SCHEDULE OF REVISED DOCUMENTS AND SUBMISSIONS

Our Reference B09117

Re: Stage 1C, Seascapes Grove, South West Rocks

RE: SEASCAPE GROVE - MP 07_0129 Preferred Project Report

Drawing Title	EXHIBIT 8: STAGE 1C TREE RETENTION PLAN AND SE BUSHFIRE ASSETT PROTECTION LOT 124 DP 1097510 SEASCAPE GROVE STAGE 1C
Project	
Client	WALDEL PARK PTY LTD
Sheet 1	Drawing No. 14777P_TREE

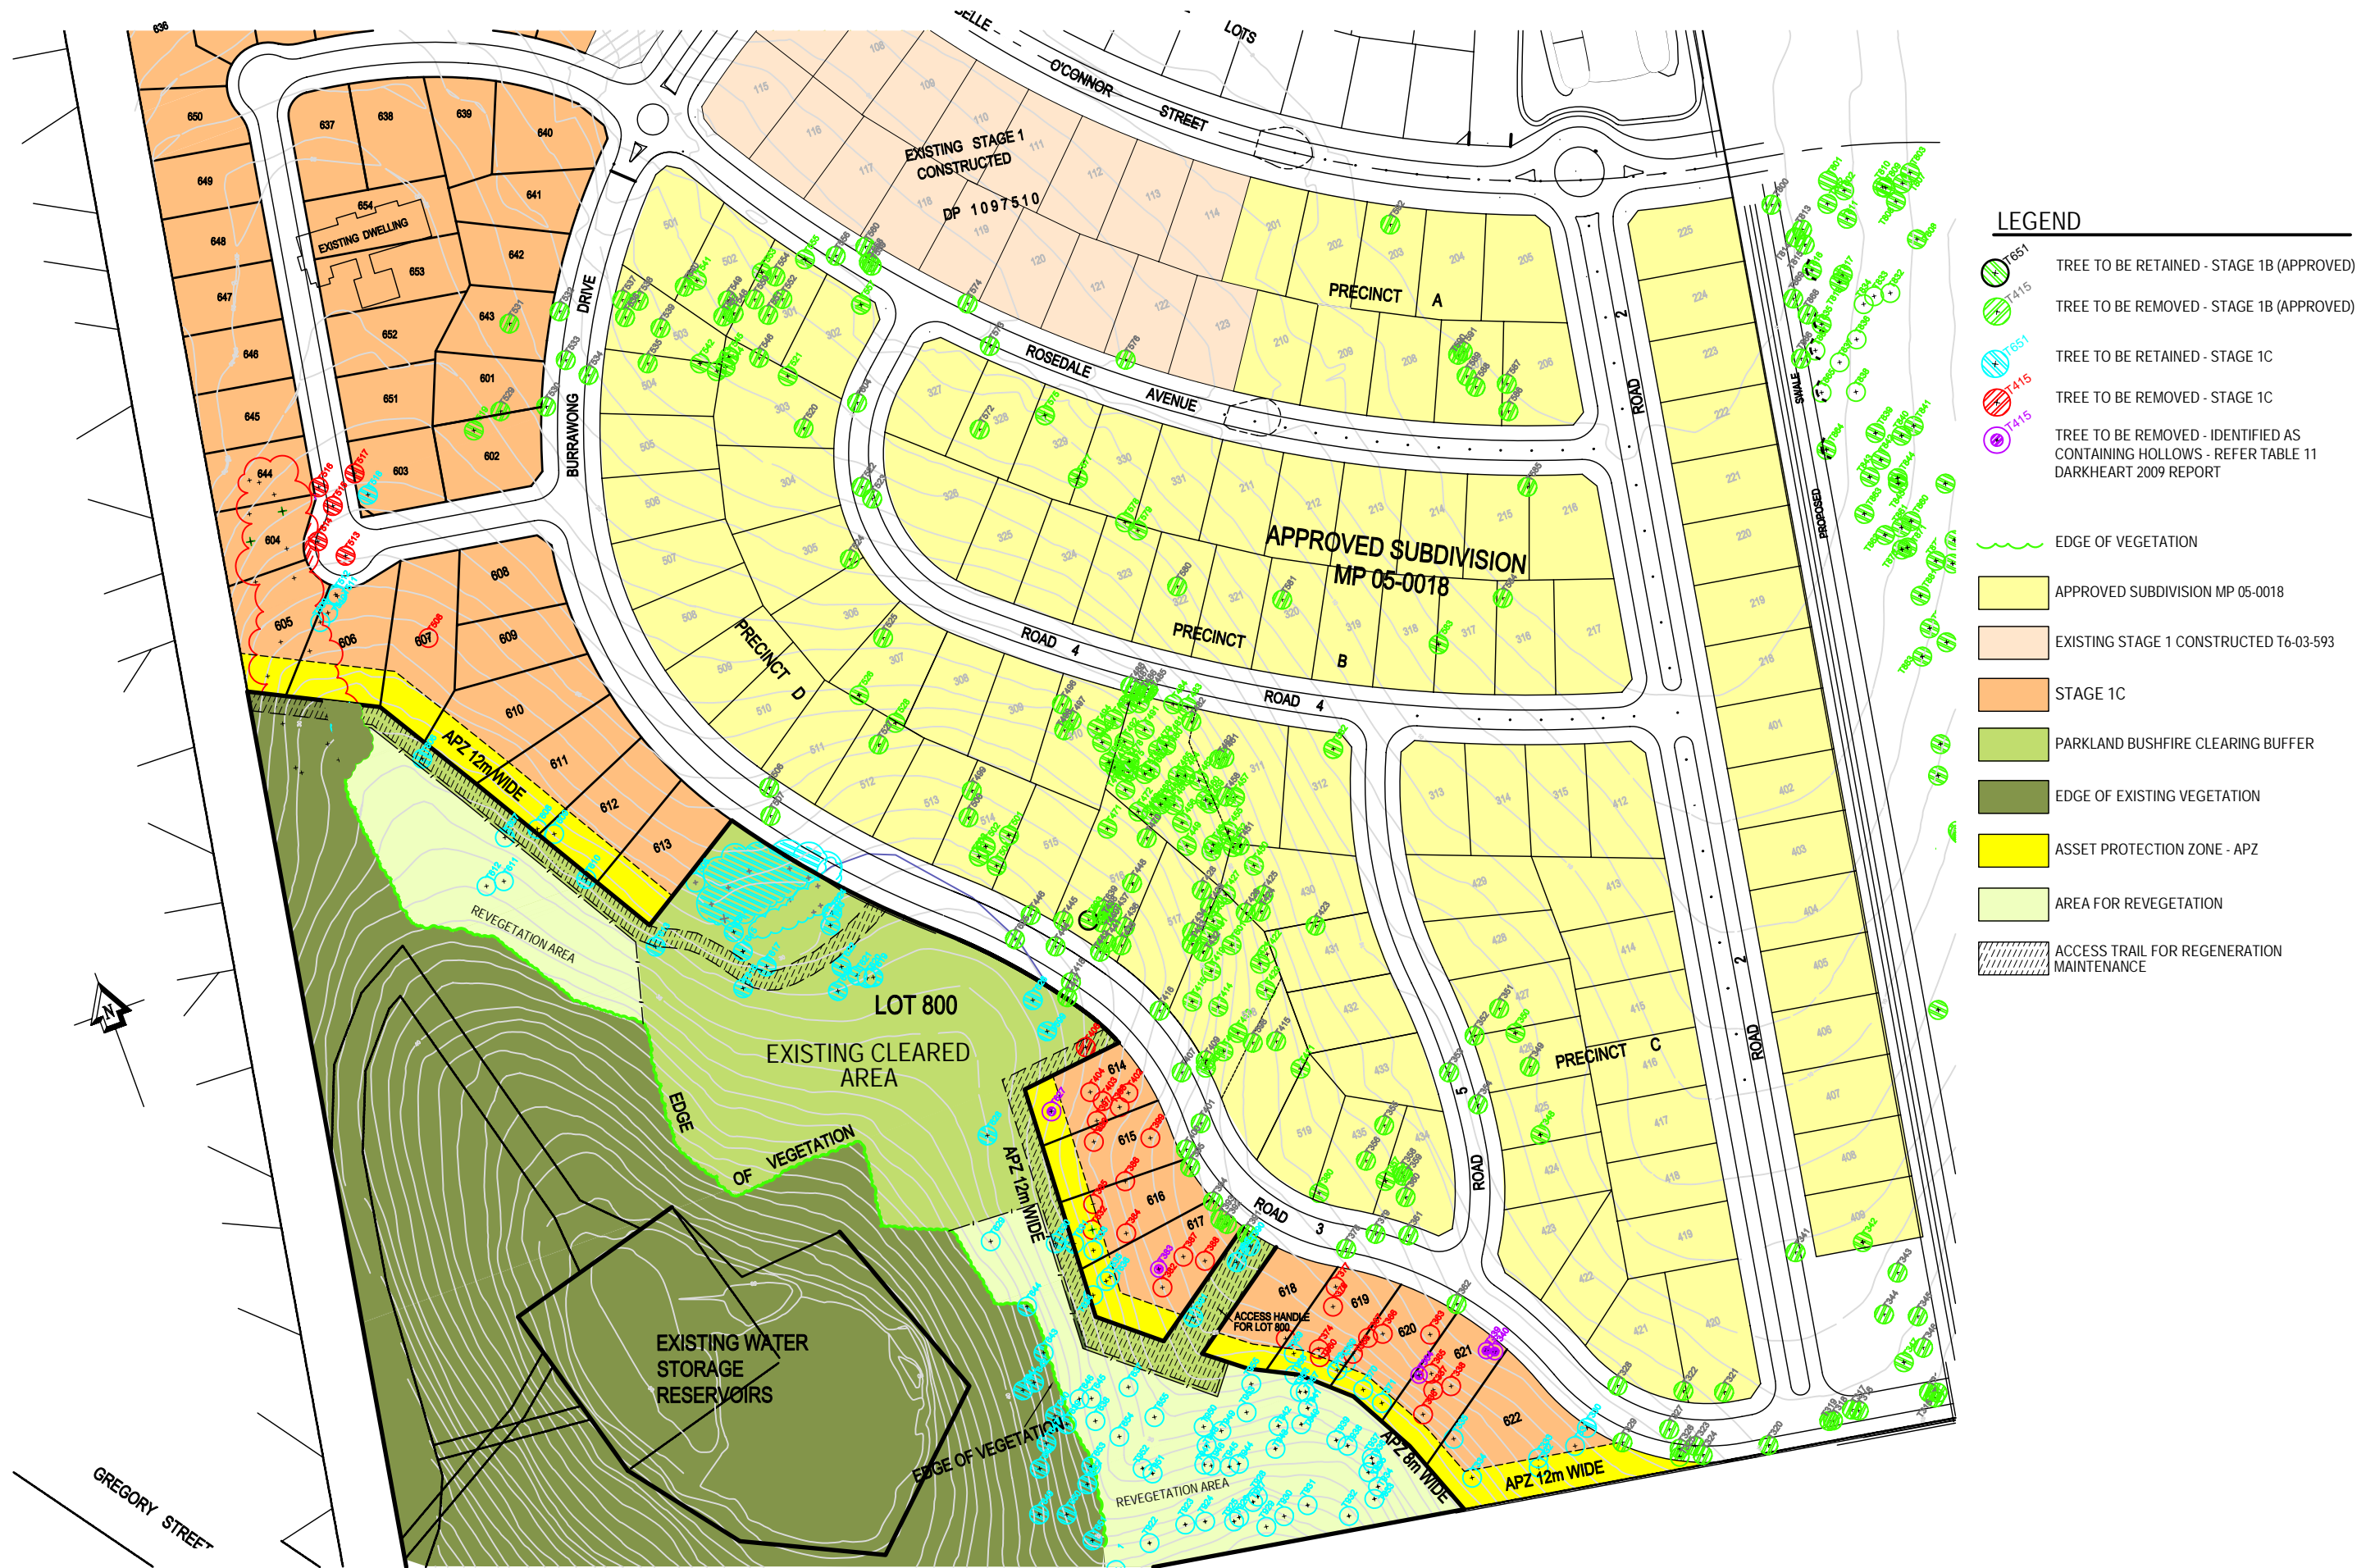
I have reviewed the amended layout for the proposed Stage 1C of the Seascapes Grove residential subdivision at South West Rocks, as presented on the Lot 800 Land Use Plan [Drawing No. 14777P_TREE, dated 9.9.2009 and confirm the following:

(1) Asset Protection Zone to Lots 605 – 607& Lots 610 – 613:

The width of the Asset Protection Zone to these lots has been recalculated using computer modelling and reduced to 12 metres, based on the dwellings on these lots being constructed to comply with Level 3 standards as defined by A.S. 3959 – 1999 – ‘Construction of Buildings in Bushfire Prone Areas’.

(2) Asset Protection Zone to Lots 614 – 617:

The width of the Asset Protection Zone to these lots has been recalculated using computer modelling and reduced to 12 metres, based on the dwellings on these lots being constructed to comply with Level 3 standards as defined by A.S. 3959 – 1999 – ‘Construction of Buildings in Bushfire Prone Areas’.

(3) Asset Protection Zone to Lots 618 – 622:

The width of the Asset Protection Zone to these lots remains as previously recommended with 8 metres to the south-western aspect of the future dwellings on Lots 618 - 622 and 12 metres to the south of the dwelling on Lot 622.

(5) Provision of Fire Trail Access for Fire-fighting operations:

A fire operational access trail shall be provided within Lot 800, located to the rear of Lots 605 – 607 and Lots 610 – 617, as shown on the Lot 800 Land Use Plan prepared by King & Campbell.

An easement shall be created, under the provisions of the Conveyancing Act of 1919, on the title of Lot 800 so that unrestricted access is provided to Council; the NSW Rural Fire Service and NSW Fire Brigade and for the maintenance of the trail by the owner of Lot 800. The width of the easement shall be 6.0 metres with the trail constructed and maintained to a width of 4.0 metres.

Locked Fire Trail gates shall be provided at the access points off the Public Road network, including the unformed road along the western side of the Estate.

The original Bushfire Protection Assessment Report recommended the provision of a fire trail along the southern boundary of Lot 622 – this requirement prevails. Due to the steep land to the southwest of Lots 618 – 622, the construction of a fire trail along the rear of these lots was not recommended – this recommendation also prevails with fire-fighting access being provided via the access handle between Lots 617 & 618.
